From: lucia@studioectypos.com
Sent: Monday, March 23, 2020 1:38 PM
To: Nicole Gaudette
Cc: michele@studioectypos.com
Subject: 74xx SE 38th St. (3623500226)

UTILITIES PLAN & PROFILE

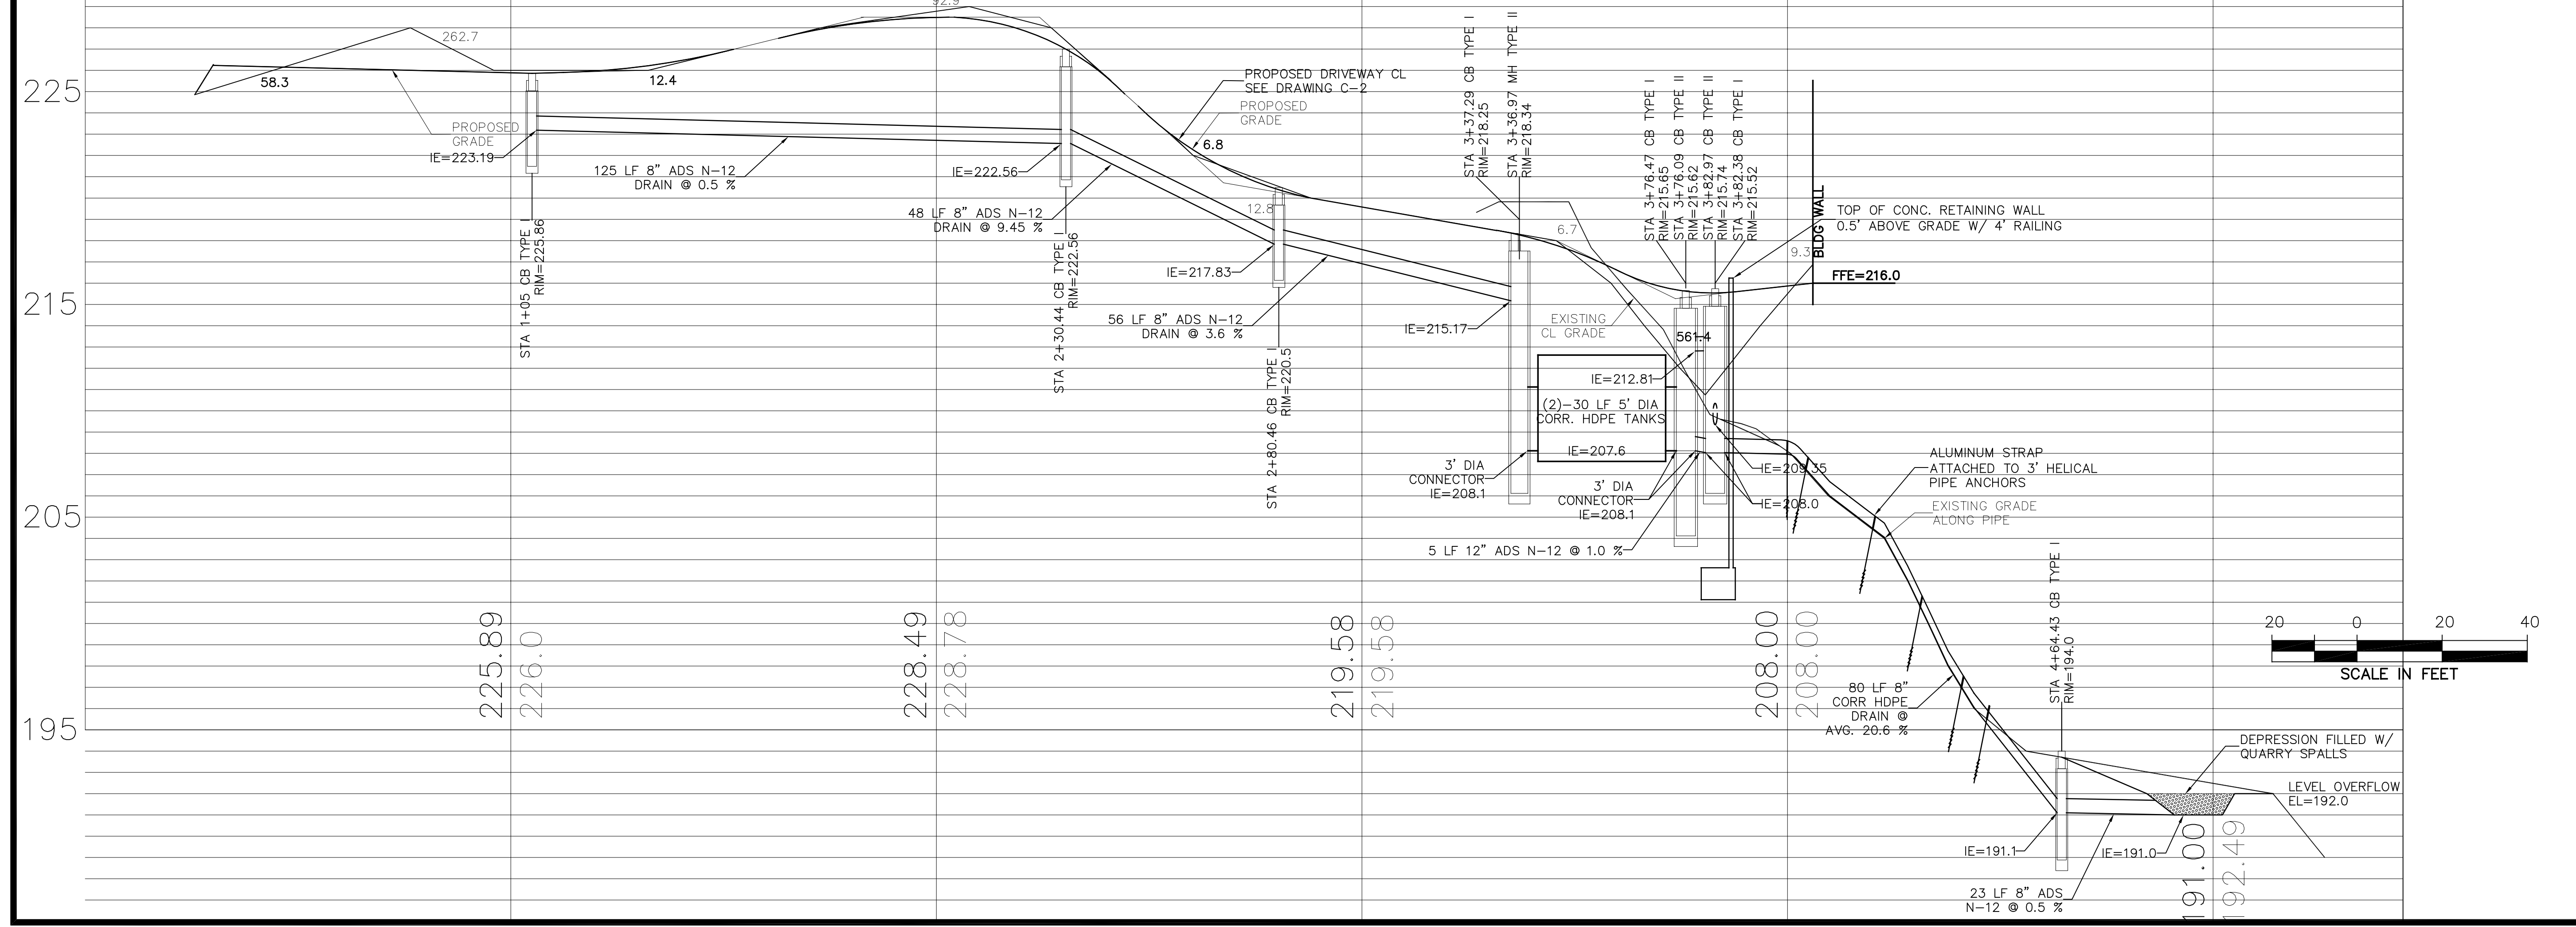
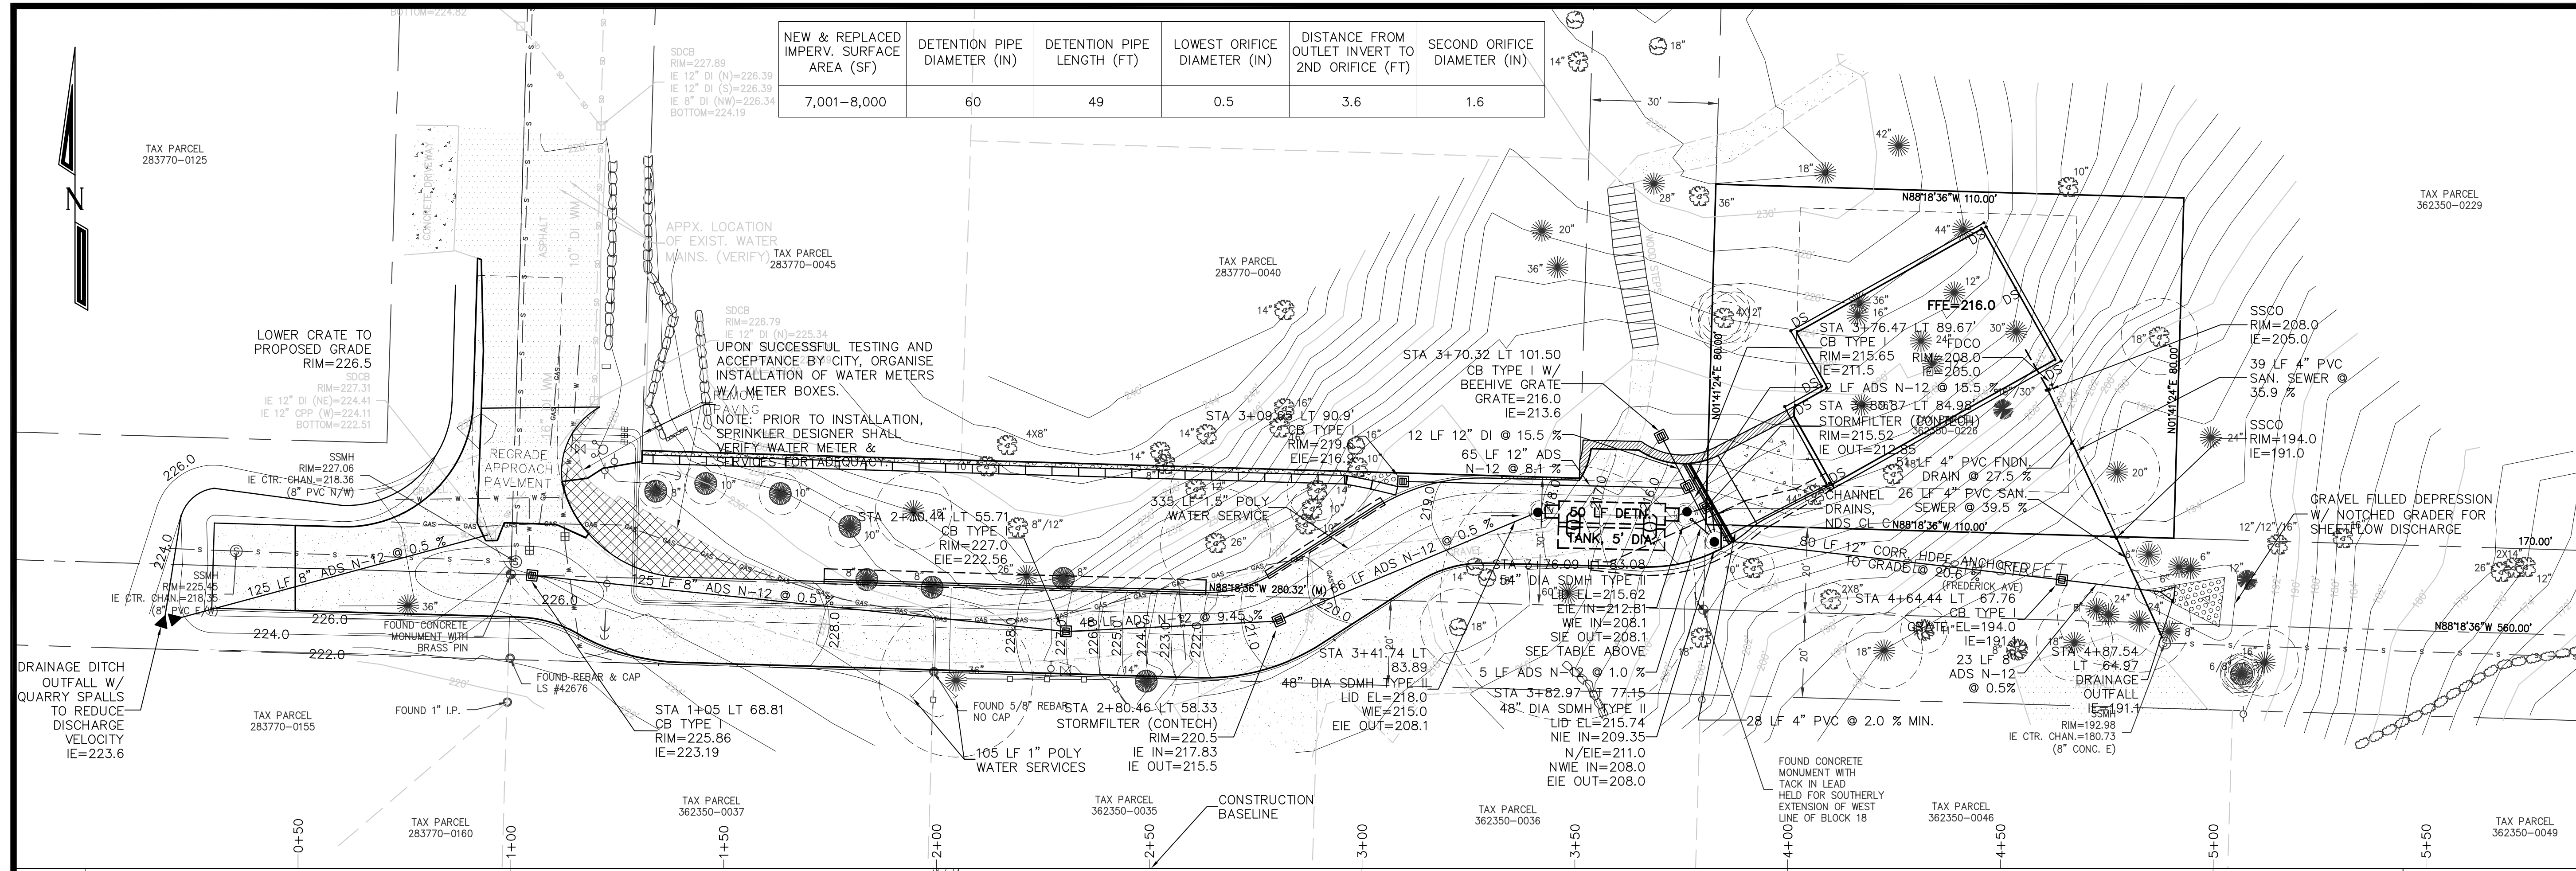
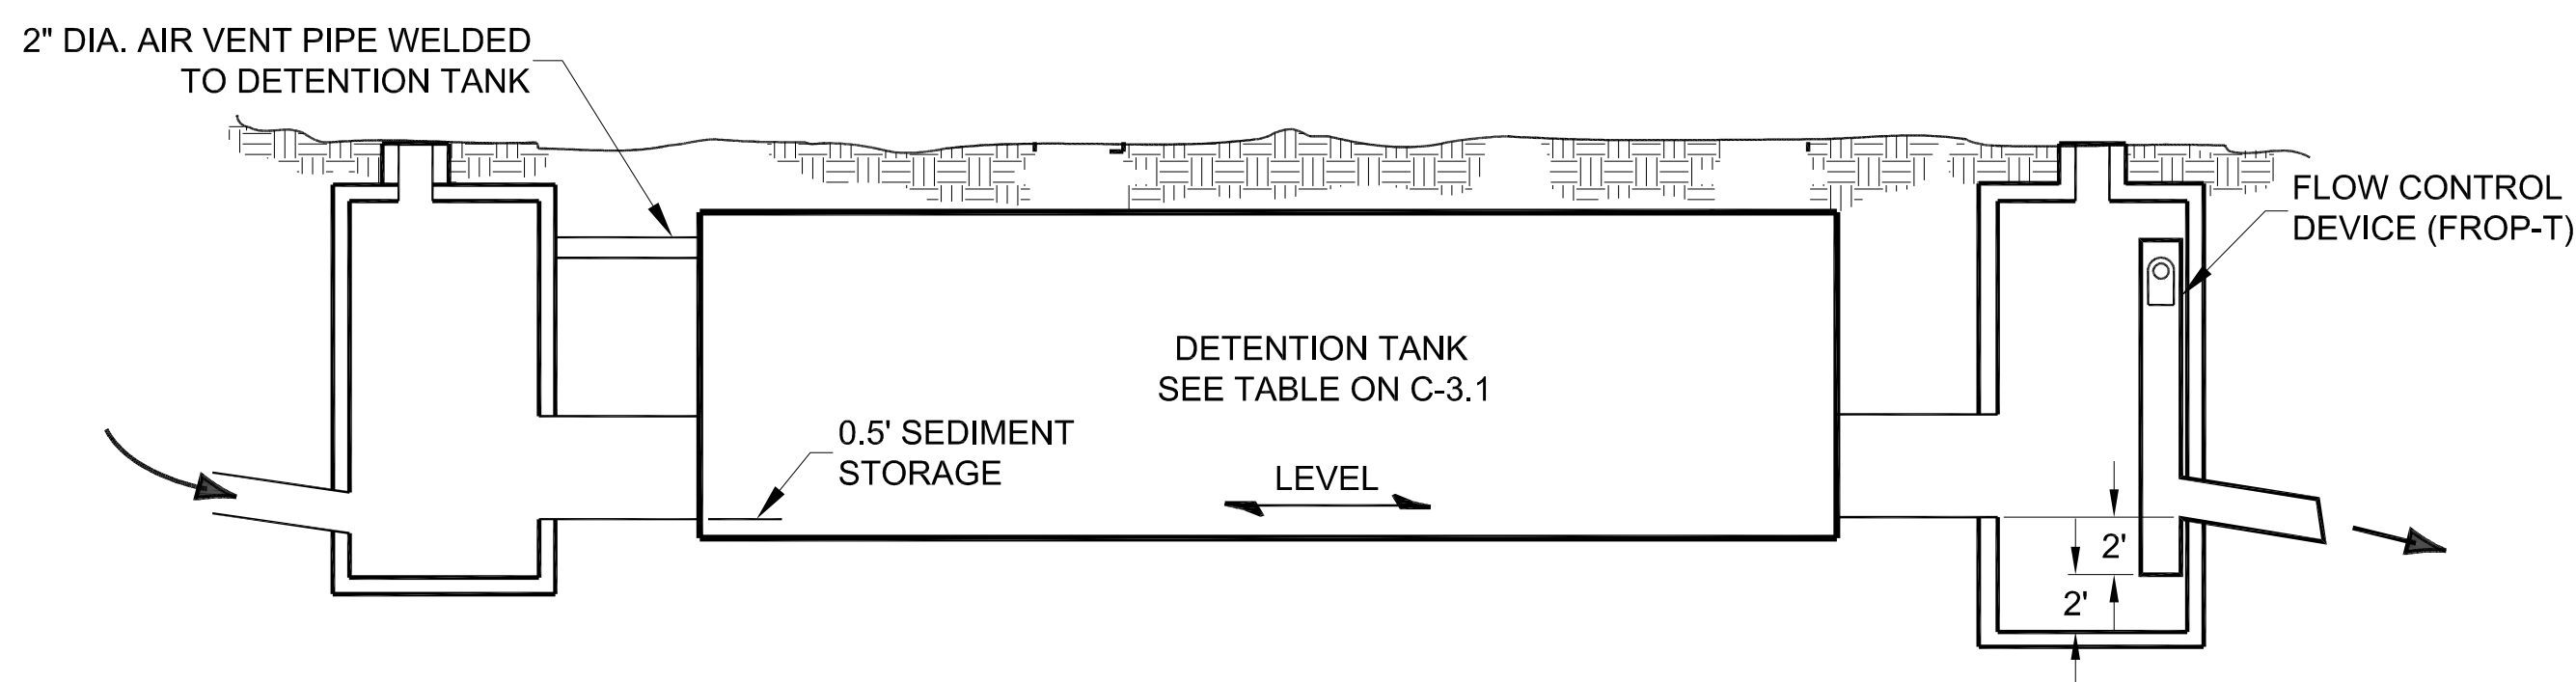
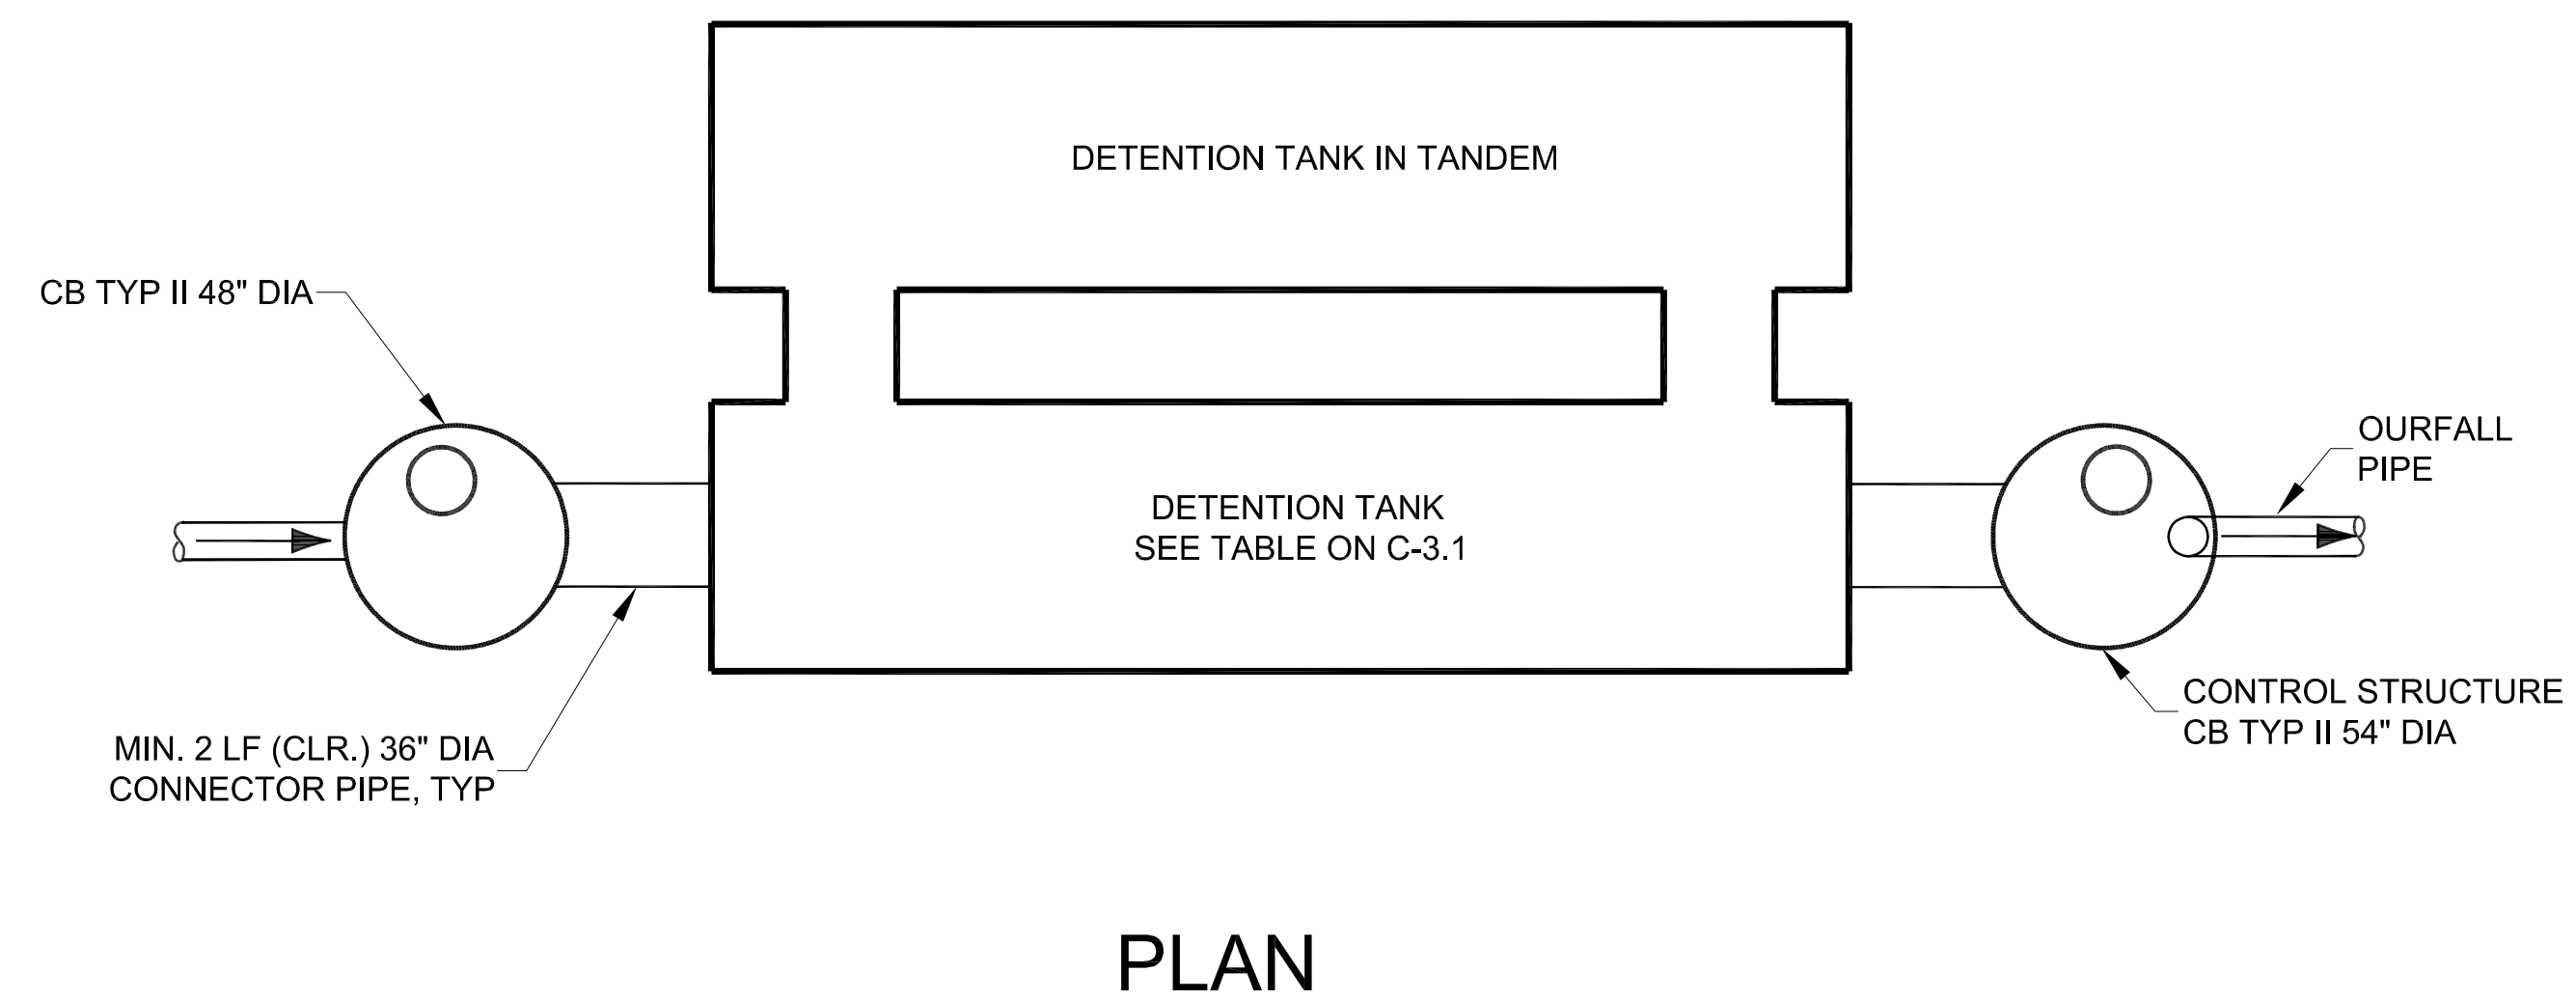
On sheet C-2 it looks like the detention system is being planned off site in the public right of way. Can you please clarify this and what the City's position is on that? It also appears that to build the access road at least one tree on private property (not subject property) is intended to be removed.
